December 15, 2023

**Re: PA22-040 – 87th & 40th PRD – Technical Review 2
4218 / 4112 / 4018 / 3922 / NNA 87th Ave NE
CORE Project No. 21036**

The purpose of this letter is to provide a response to the review comments for PA22-040 – 87th & 40th PRD – Technical Review 2 - 4218 / 4112 / 4018 / 3922 / NNA 87th Ave NE dated October 24, 2023. We have addressed each comment and revised the plan/documentation accordingly. This letter contains the review comments immediately followed by our response to each in bold lettering.

ENTERING SIGHT DISTANCE EXHIBIT
87TH AND 40TH PRD
PNW INVESTORS, LLC
PO BOX 1930
WOODINVILLE, WA 98072

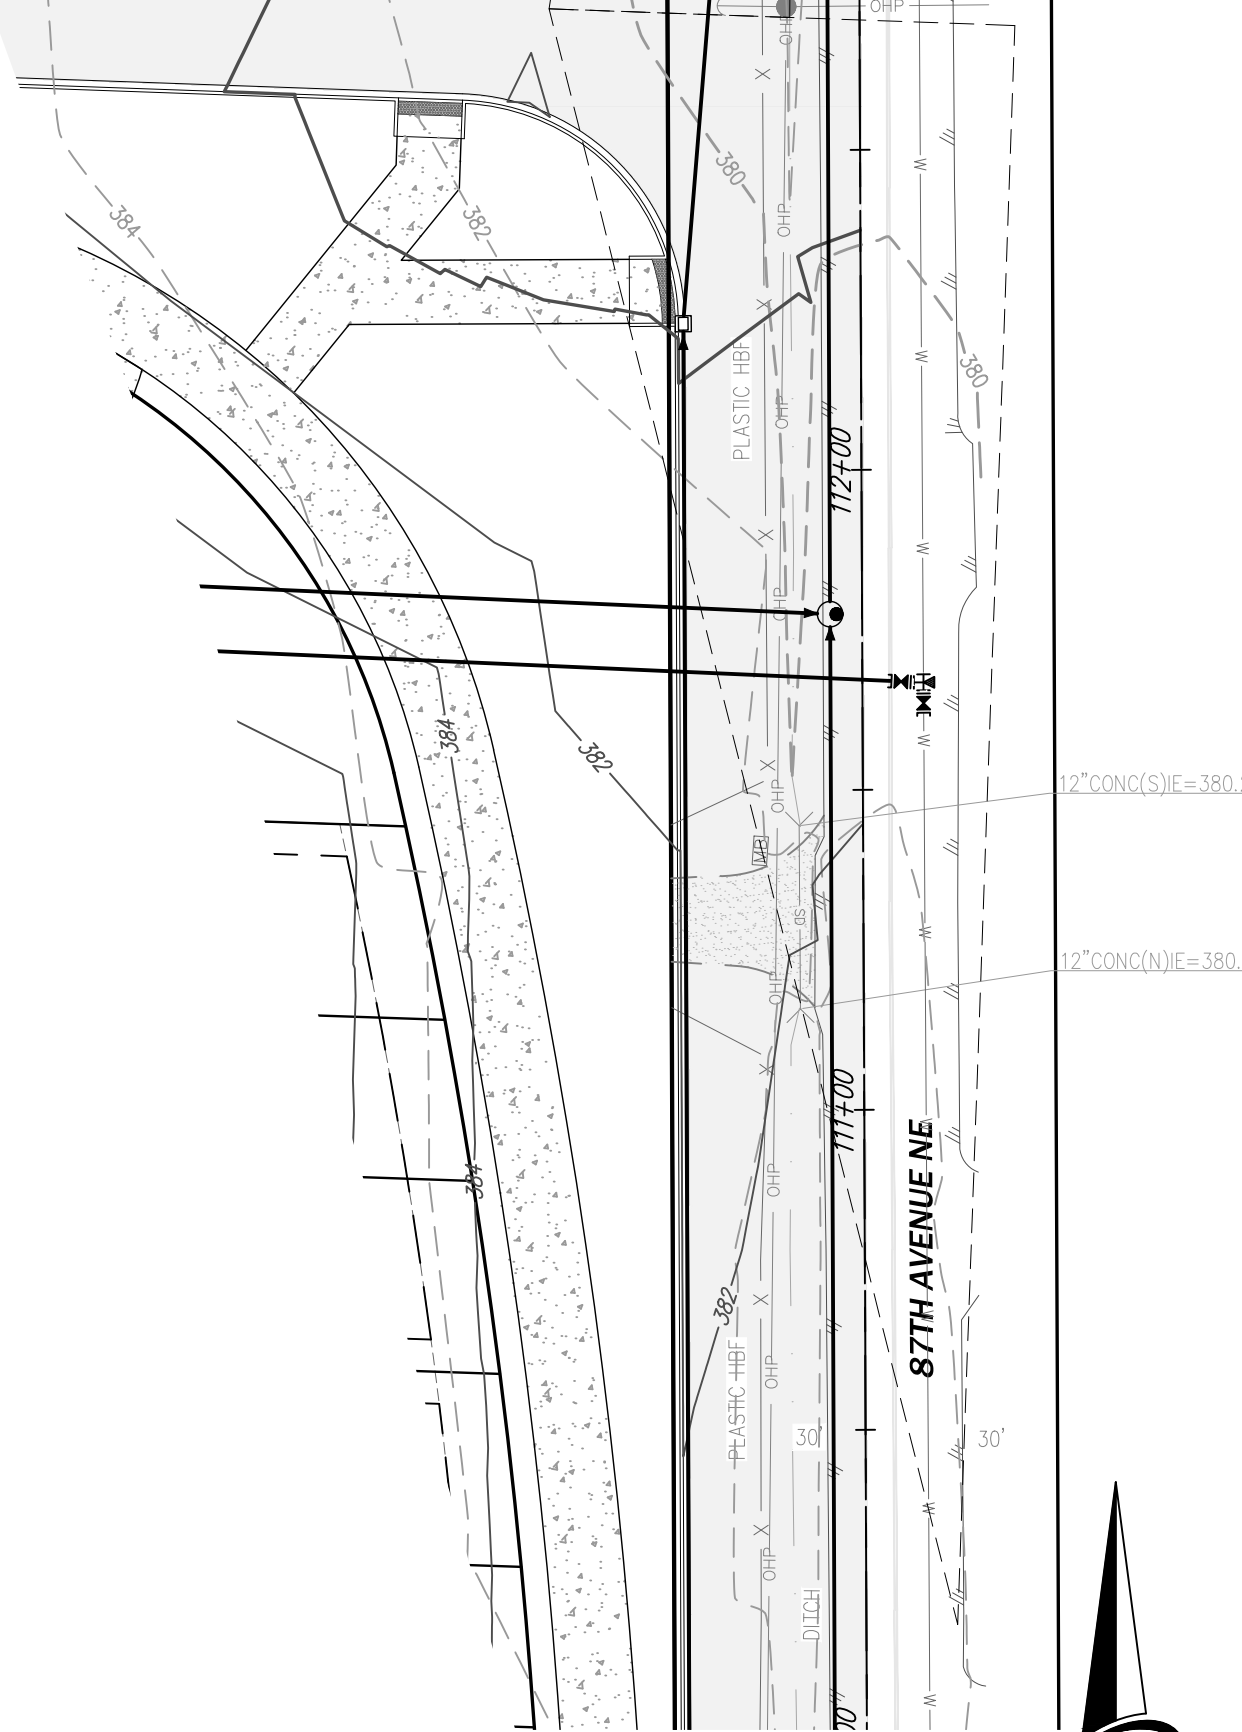
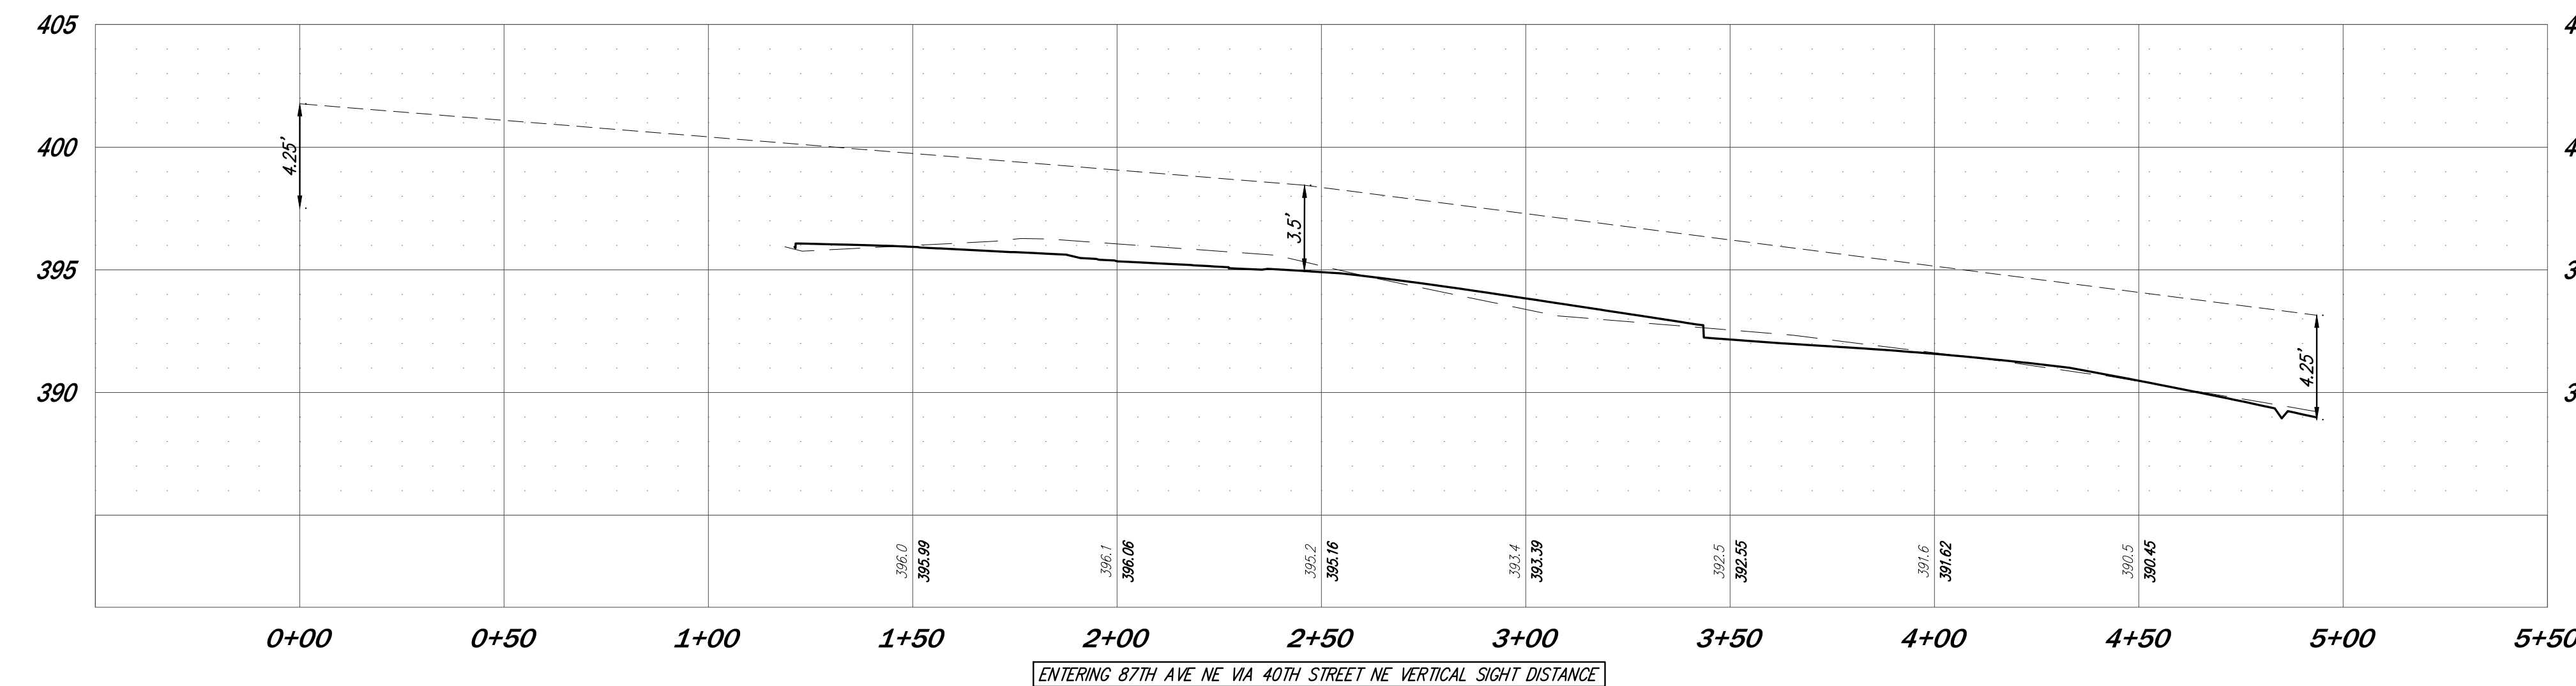
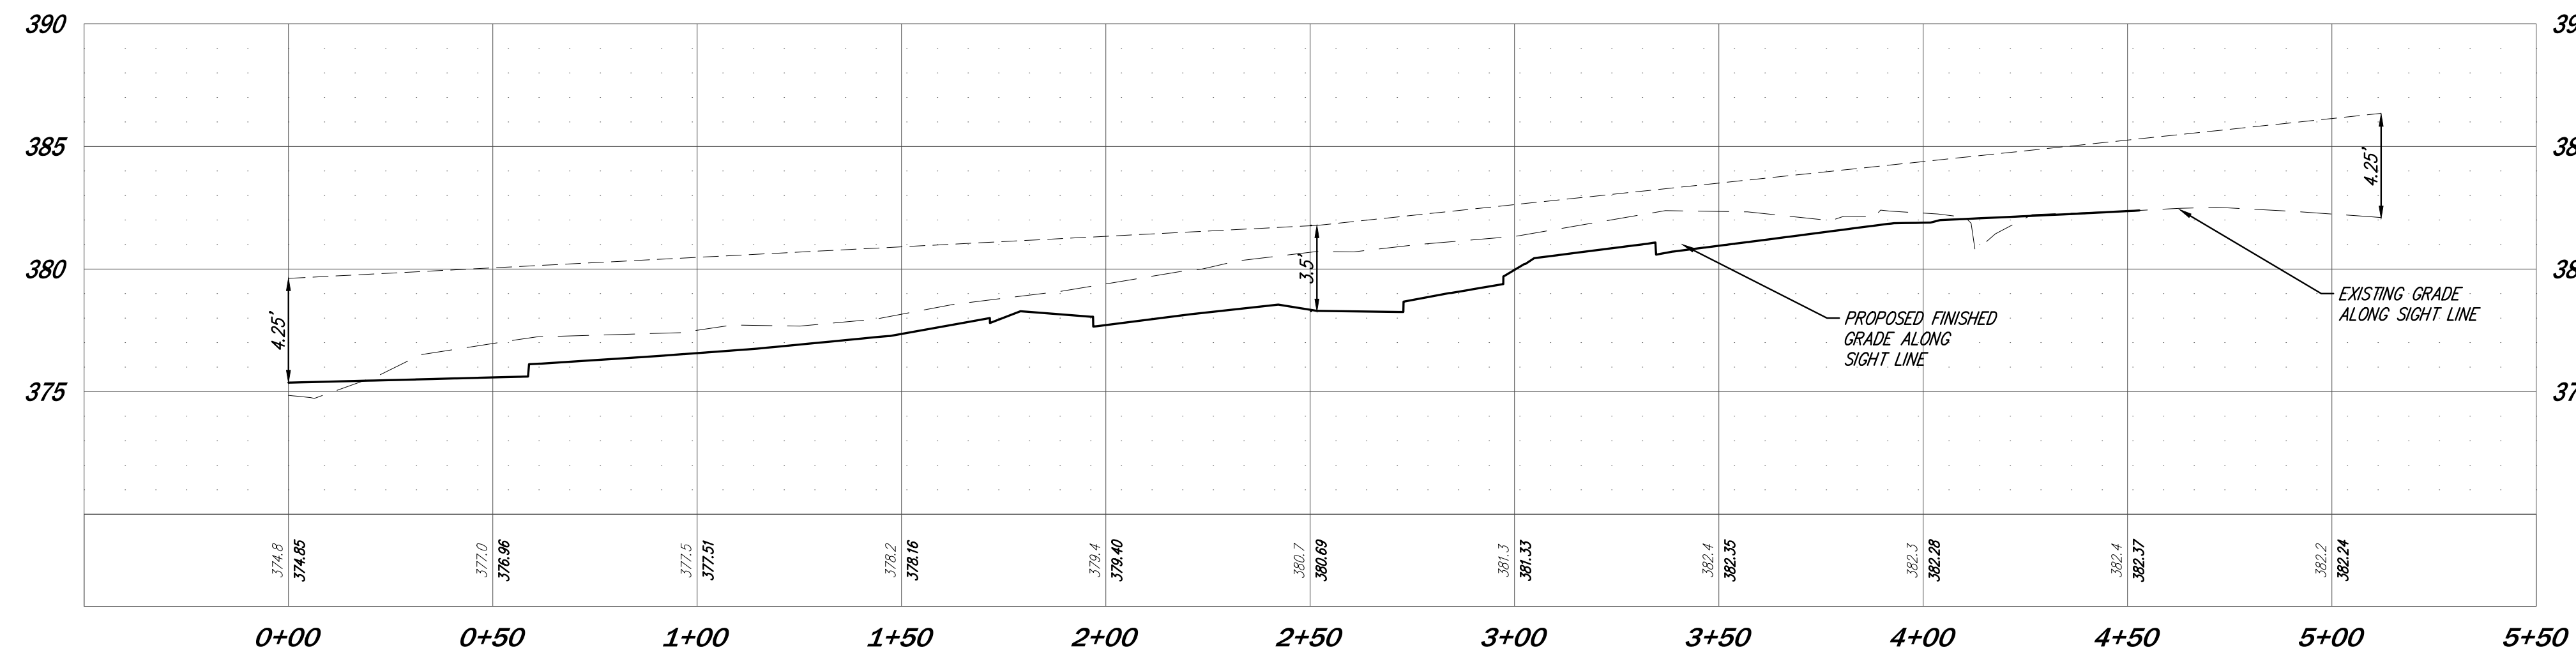
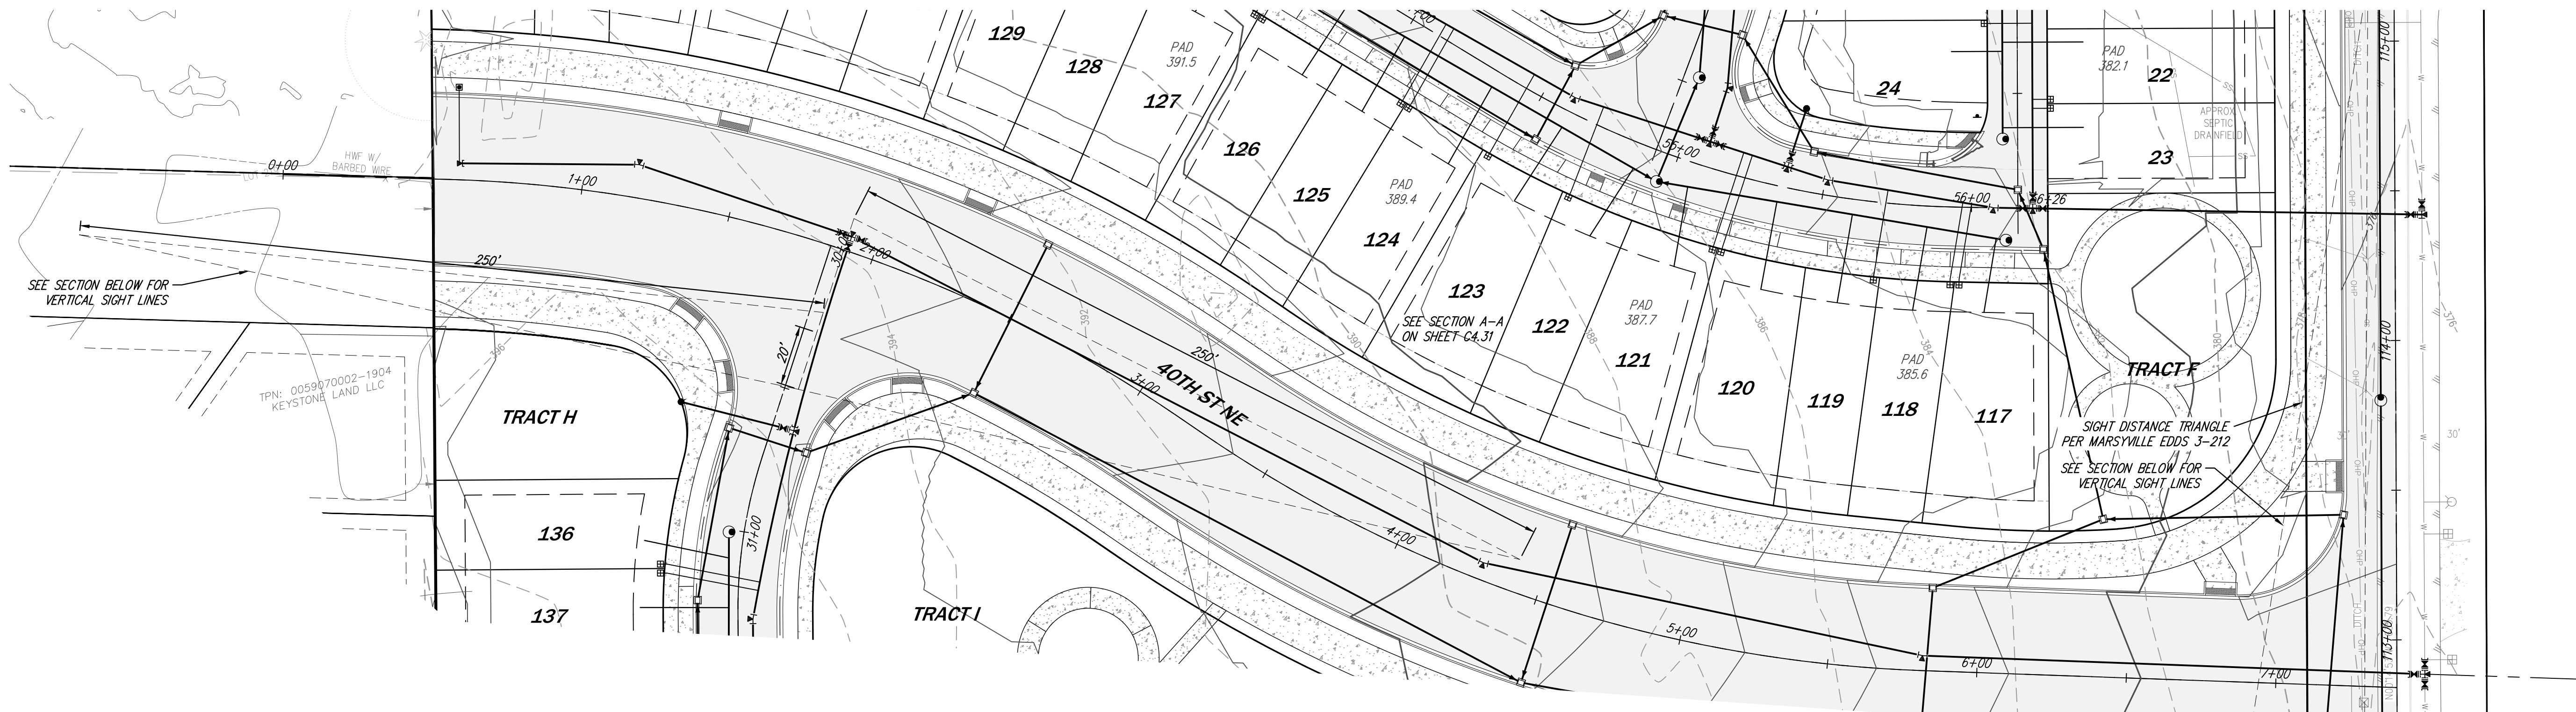
8. Per EDDS 3-312, Intersection sight distance for both new roadways shall be evaluated.

9. Per EDDS 3-301, Arterial Access Management standards apply:
 - a. 40th ST NE:
 - i. Full access may not be allowed from development directly onto 40th ST NE based upon feasibility of maintaining intersection sight distance given likely vertical alignment of roadway.
 1. Access point onto 40th ST NE between 83rd Ave NE and 87th Ave NE may be required as a right-in/right-out only access.
 2. Sight distance analysis including roadway plan and profile shall be supplied to evaluate proposed access location.

Response: Sight distance analysis has been provided on sheets C7.21 and C7.22.

Response: A sight distance analysis has now been provided. This analysis can be found on sheet C7.22.
